**CITY OF MERCER ISLAND
REASONABLE USE EXCEPTION
STAFF REPORT & RECOMMENDATION**

**Agenda Item: 1
February 13, 2017**

Project Number:	CAO15-001
Description:	The applicant is proposing to locate a single family residence in a Category III wetland and its associated buffer, and in a Type 2 watercourse buffer. The subject lot is significantly encumbered by critical areas and their associated buffers. The proposed residence will result in approximately 5,332 square feet of impervious surface, resulting in a lot coverage of approximately 14.2%. The total disturbance proposed to critical areas is approximately 6,318 square feet.
Applicant:	Bill Summers for MI Treehouse, LLC
Address:	5637 East Mercer Way, Mercer Island WA 98040; Identified by King County Assessor tax parcel number 1924059312
Zoning District:	R-15, Single Family Residential (minimum lot area of 15,000 square feet)
Staff Contact:	Evan Maxim, Planning Manager
Hearing Date:	February 13, 2017
Staff Recommendation:	Denial of the proposed reasonable use exception

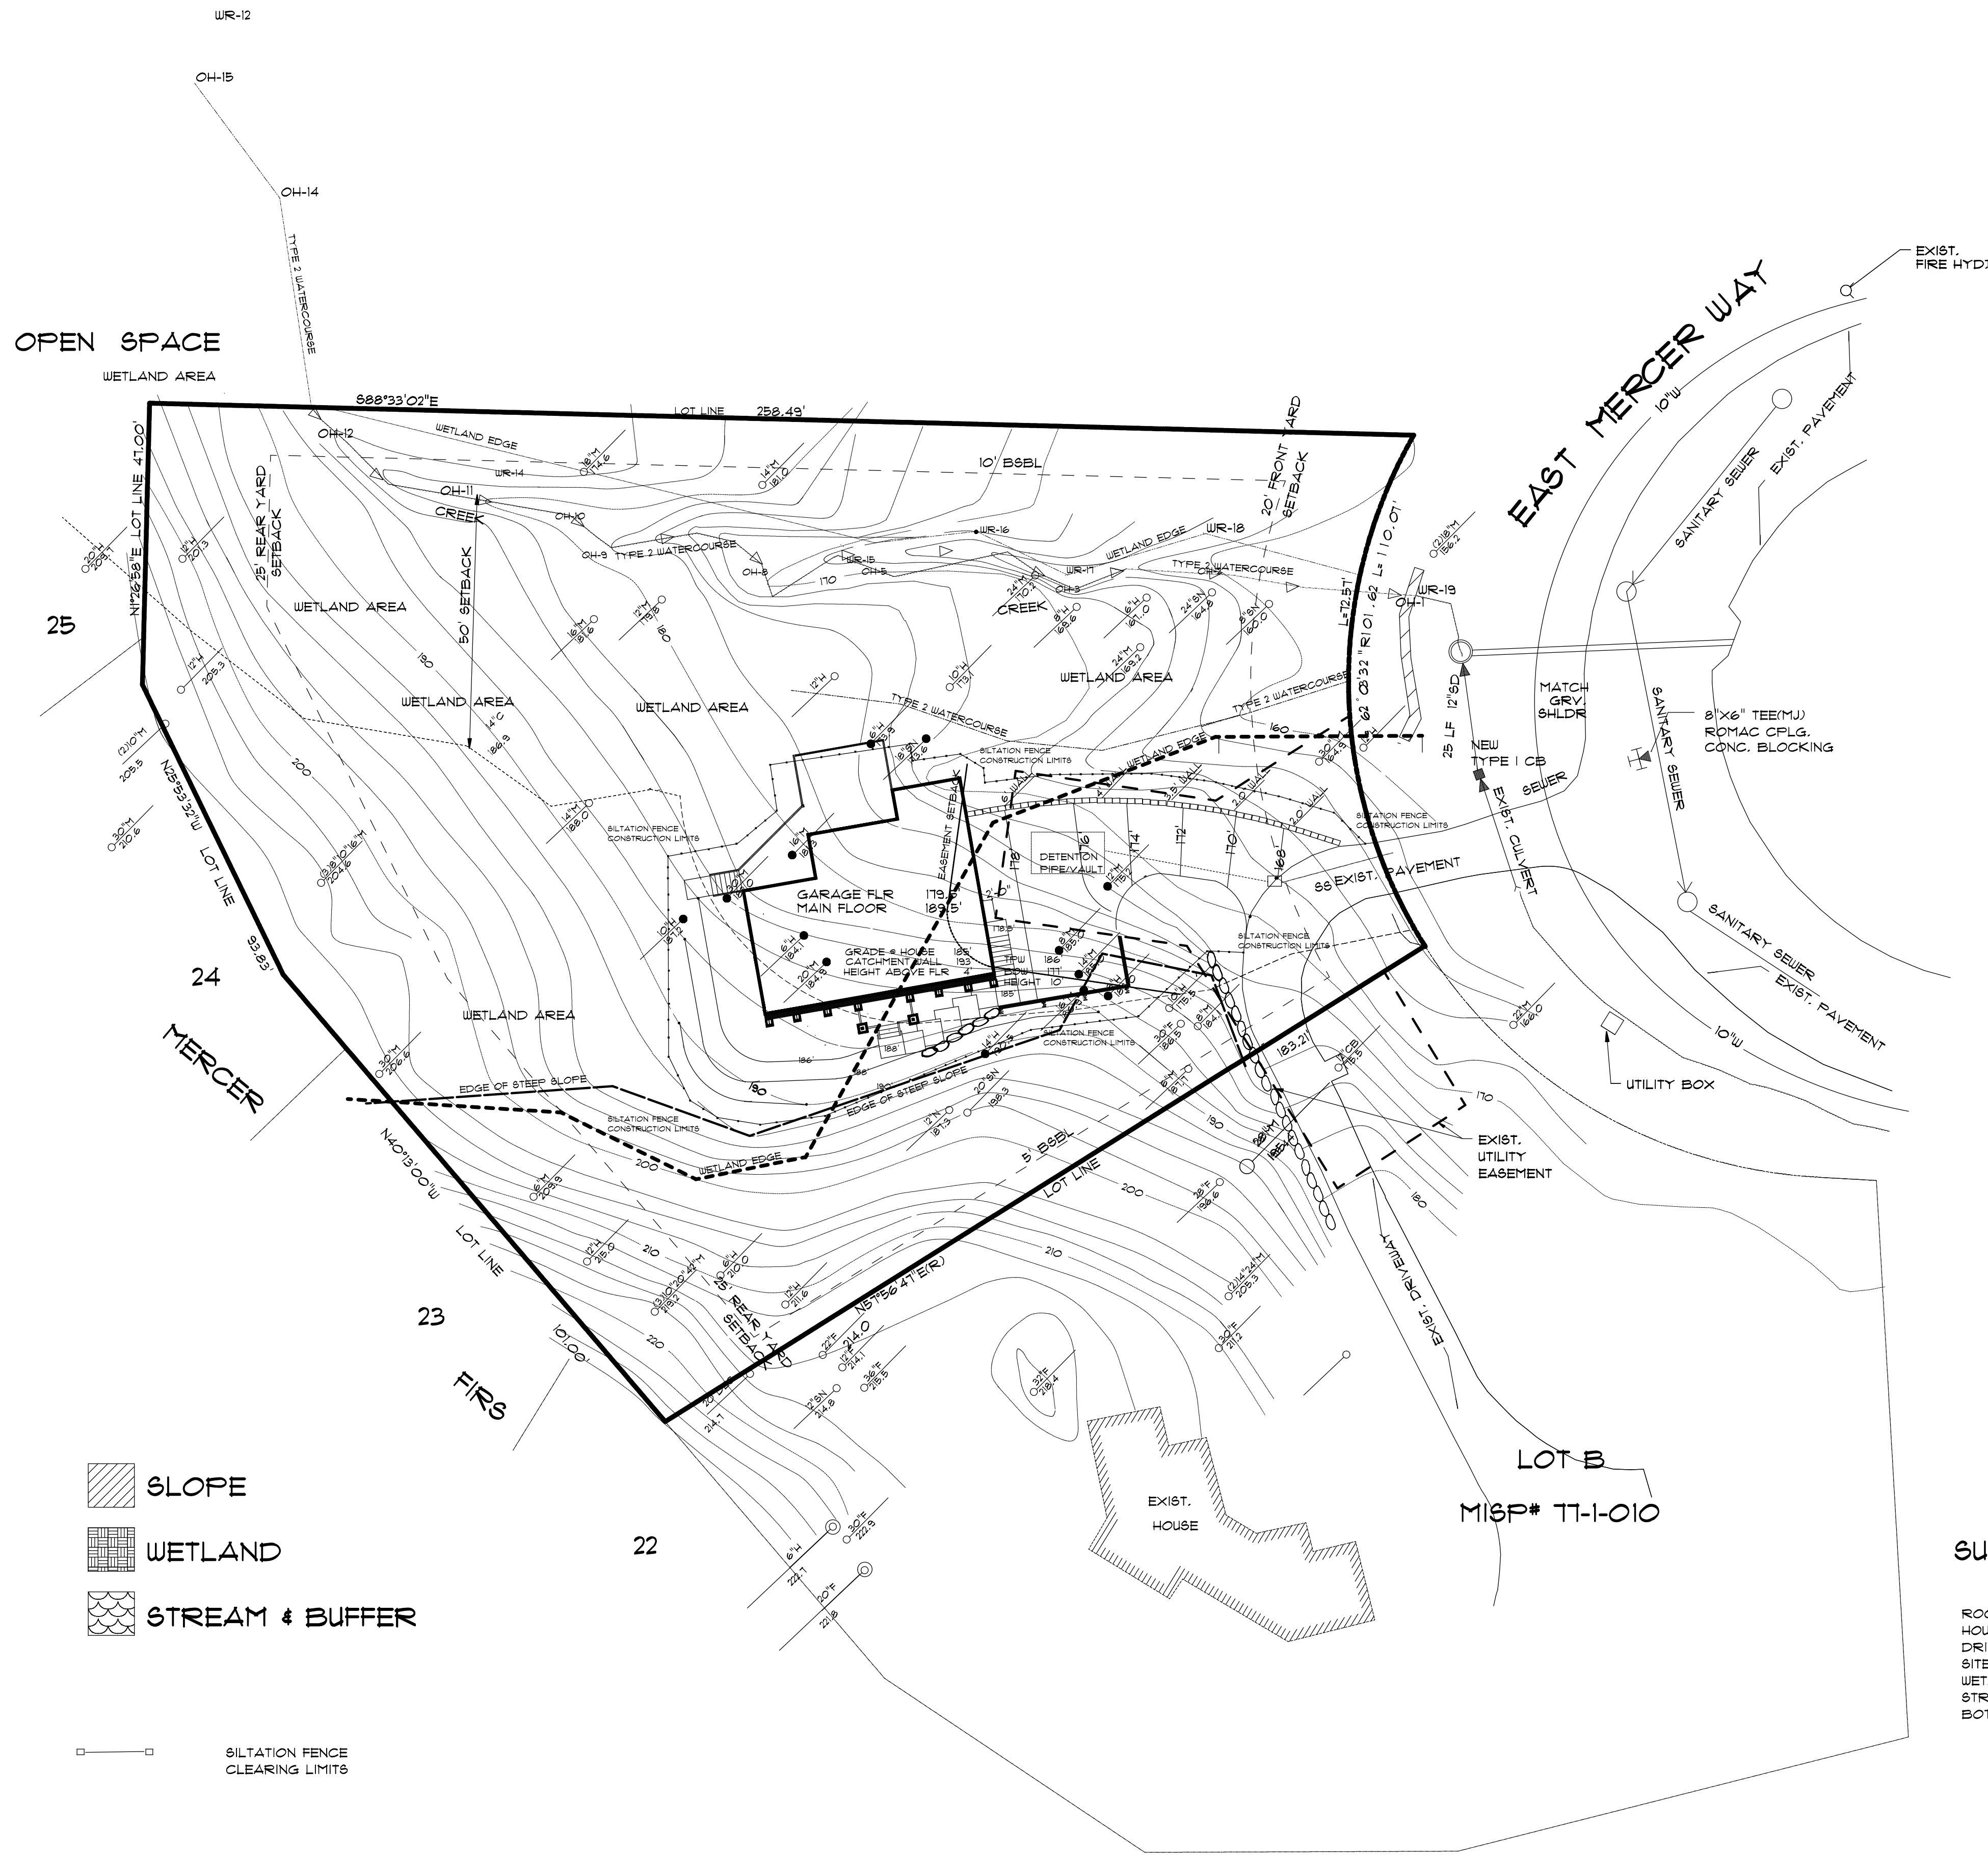
The applicant has failed to locate the house footprint to minimize the wetland and watercourse impacts that are the subject of review under this reasonable use exception. The proposed house is located approximately 20 feet west of the edge of the road and utility easement created through the short plat. By shifting the house to the east and south, intrusion into the wetland and required stream buffers would be further minimized.

The conceptual design of the proposed house reflects a living space of approximately 2,560 square feet, together with a garage area of 1,155 square feet for a total gross floor area (GFA) of 3,713 square feet. The proposed building design includes the use of approximately 650 square feet of clerestory space over the front entry and family room.

The City requires that every single family home provide two covered parking spaces (ref. 19.02.020(E)); a typical two stall garage with access to a second story would result in building footprint of approximately 800 square feet or less. By eliminating cantilevers and second story decks the total area of impact for such a house would be far less than the proposed amount of direct wetland disturbance and watercourse buffer impacts. The applicant has provided no analysis for possible site alternatives to further minimize wetland impacts.
